Our Ref: NW/ARU/19/04A

RE Land at Saltbox West of Shripney Road Bognor Regis PO22 9NW

Thank you for your correspondence of 15th February 2019 regarding 'Approval of details reserved by condition imposed under ref BE/102/17/OUT relating to Condition No 17, CCTV. Condition No 19, acoustic barriers. Condition No 21 external lighting and Condition No 22 Broadband for which you seek advice from a crime prevention viewpoint.

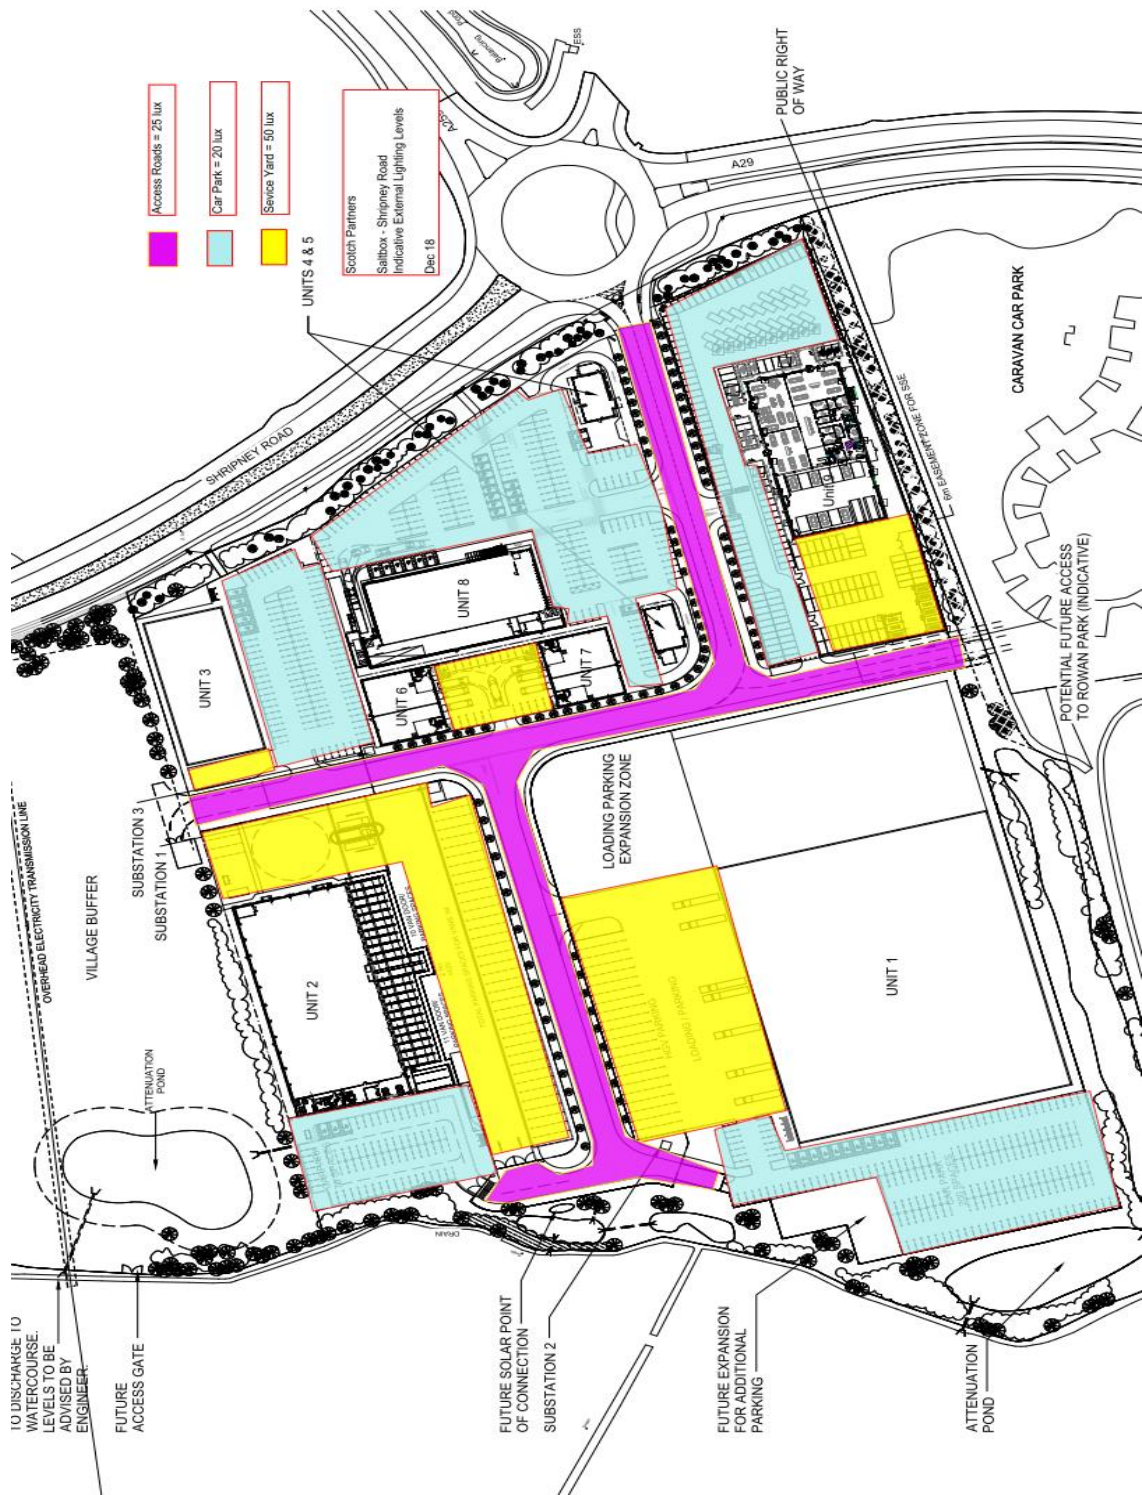
External Lighting must conform to BS5489 -1:2013, which has been referred too within the lighting plan submitted along with other technical specifications. SBD Commercial Developments 2015 Chapter 48 gives recommendations regarding lighting requirements. Lighting should be carefully used to illuminate entrances and vulnerable areas and be commensurate with the CCTV system used.

1 PROPOSED GROUND FLOOR PLAN
1 : 250

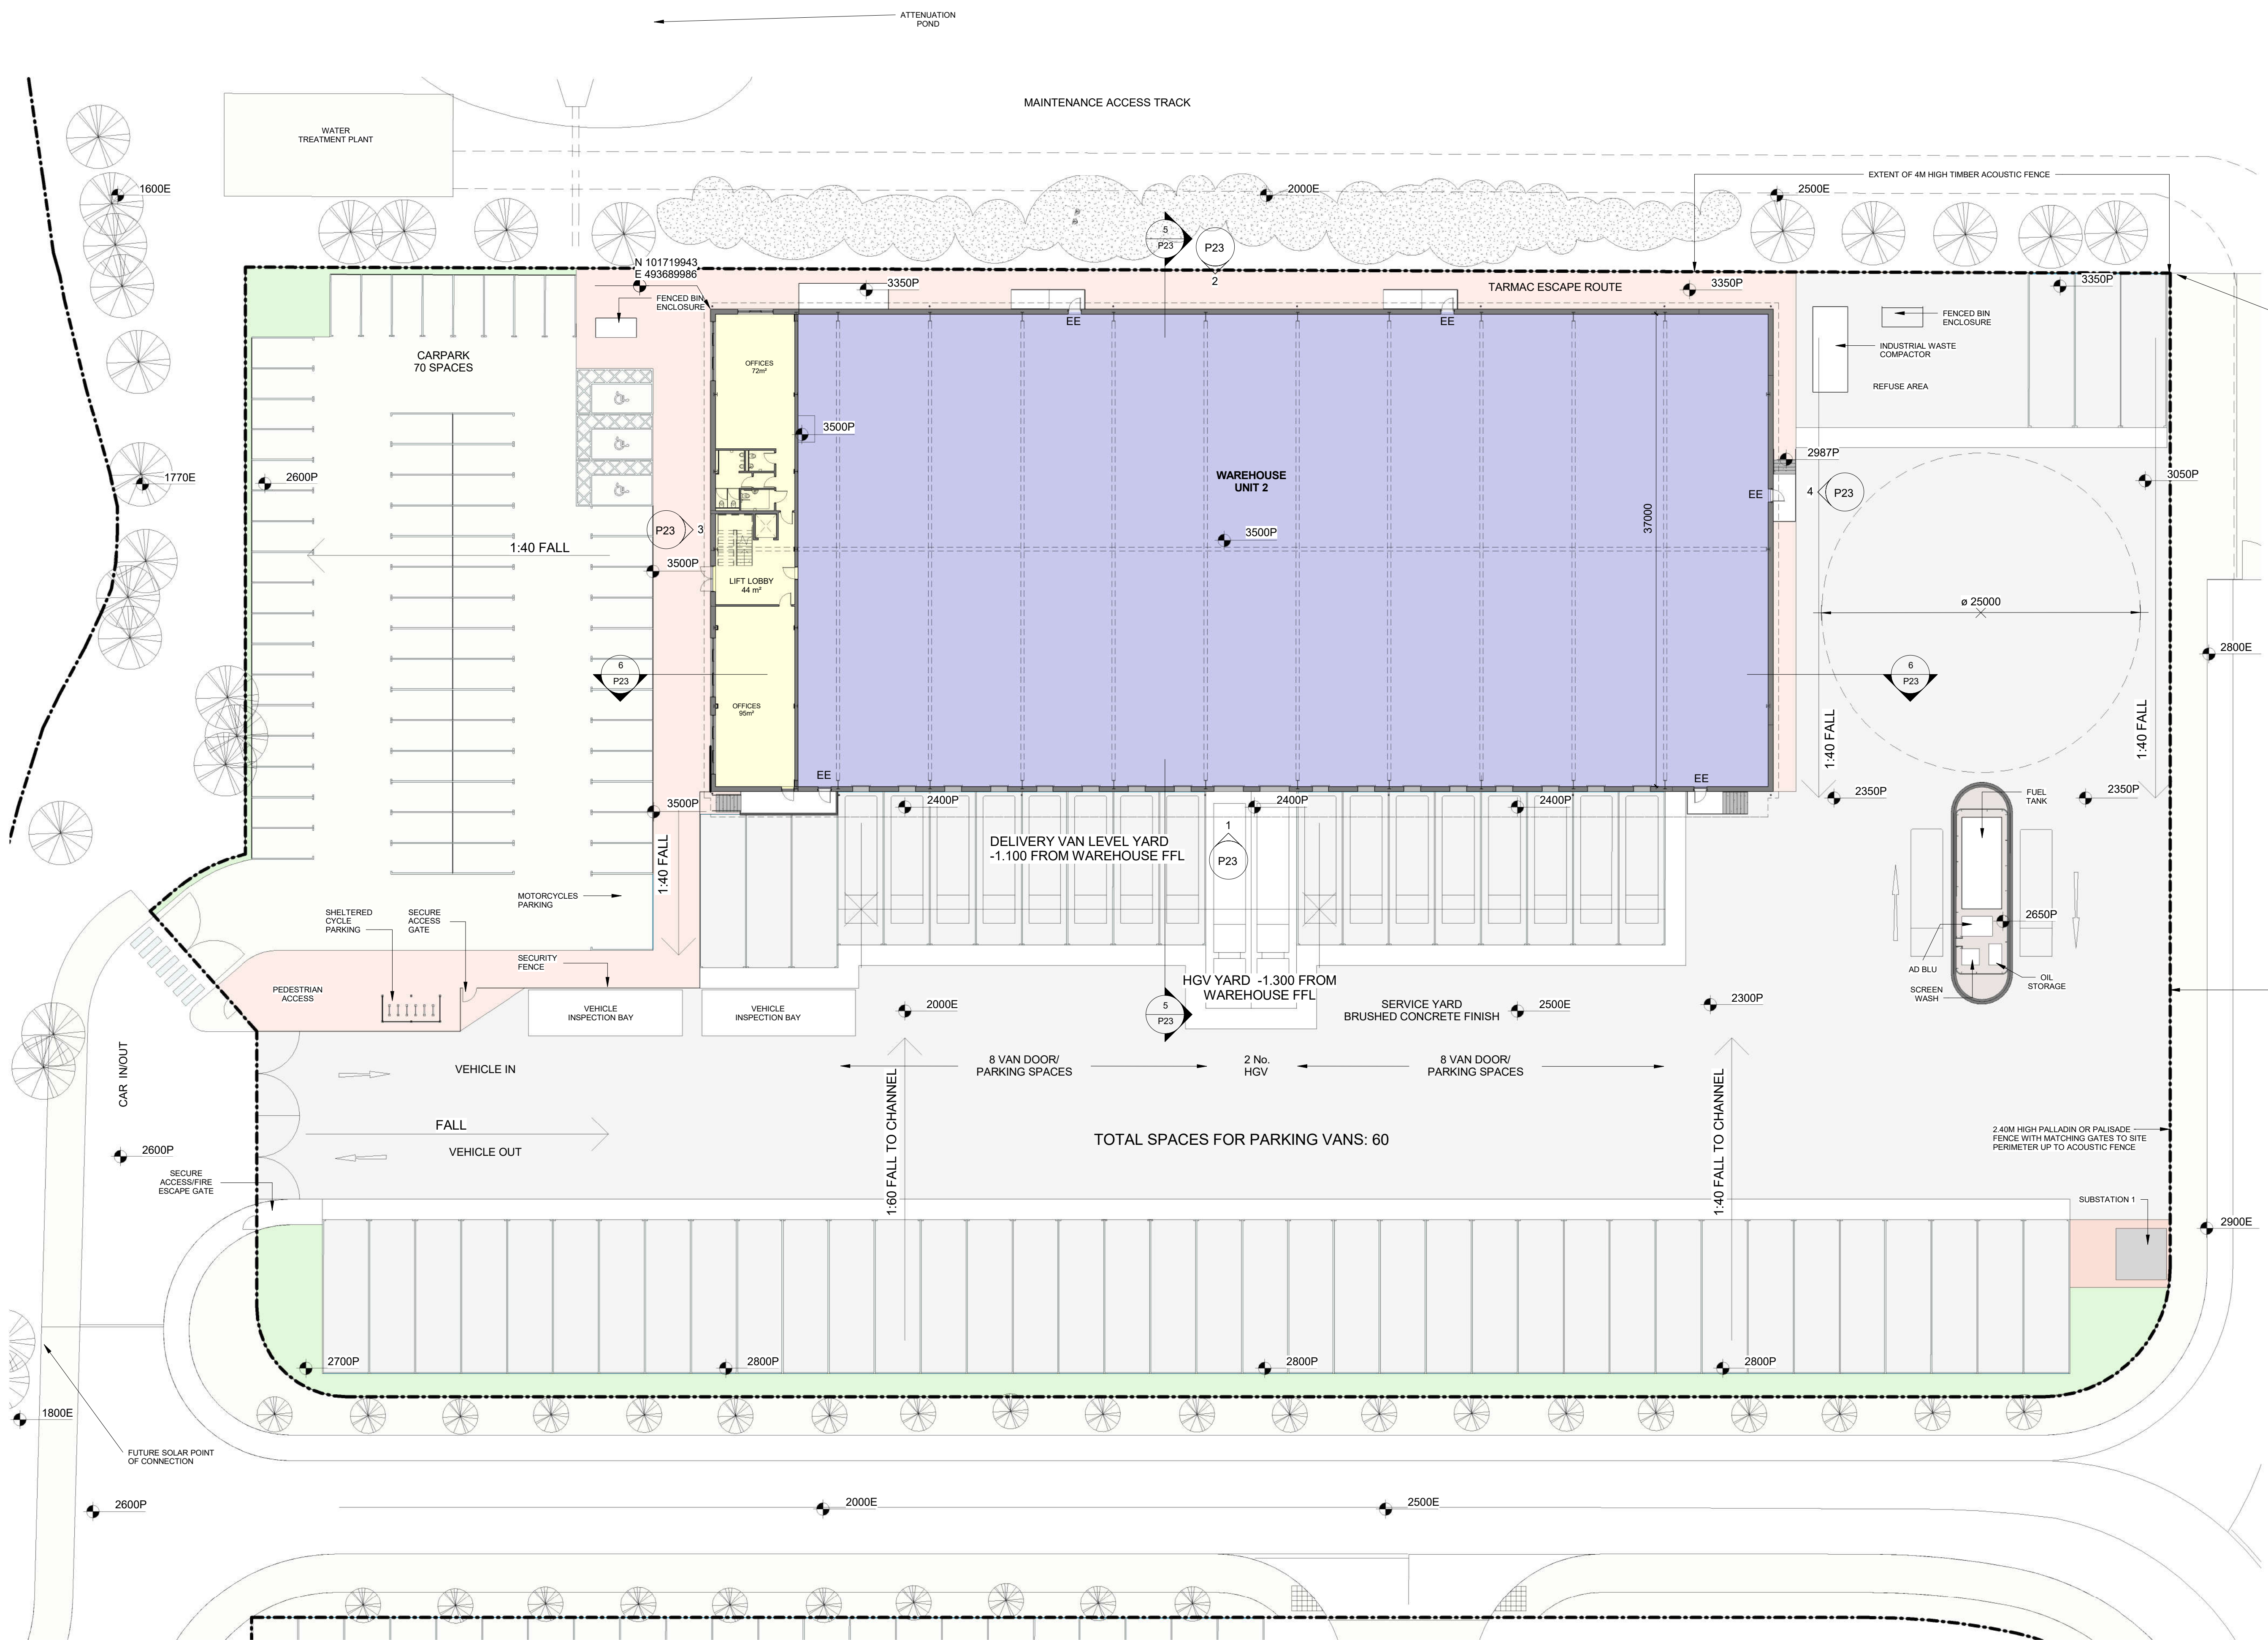
Regarding acoustic fencing located on the north east boundary of Unit 2, I make the following comments

From a crime prevention viewpoint the acoustic fencing can help provide a layer of security if combined with other security measures. It can deprive visibility to sensitive areas as well as reduce sound levels and provide a physical barrier, but can also deprive causal observation of an area by members of the public and staff, which must be accounted for by other means.

I recommend the acoustic fencing is fit for purpose and as far as possible designed to deter any attempt to climb it by providing no areas to gain a foothold, or to break through it due to a flimsy structure or weak material or by climb under it.

Acoustic fencing is primarily designed to reduce noise from travelling from area to area, and not necessarily designed for security. However when built to 4.00 metres in height most fencing will offer a degree of security, especially against climbing over, providing there are no aids to assist climbing on the attack side which would assist unauthorised access, such as horizontal cross bars or Arris rails that may provide footholds.

SBD Commercial Developments 2015 document Chapter 43.13 advises the top of timber fences should be finished flush with neighbouring posts and a securely fixed capping rail should run across the top of the fence to create a continuous chain to deter climbing over.
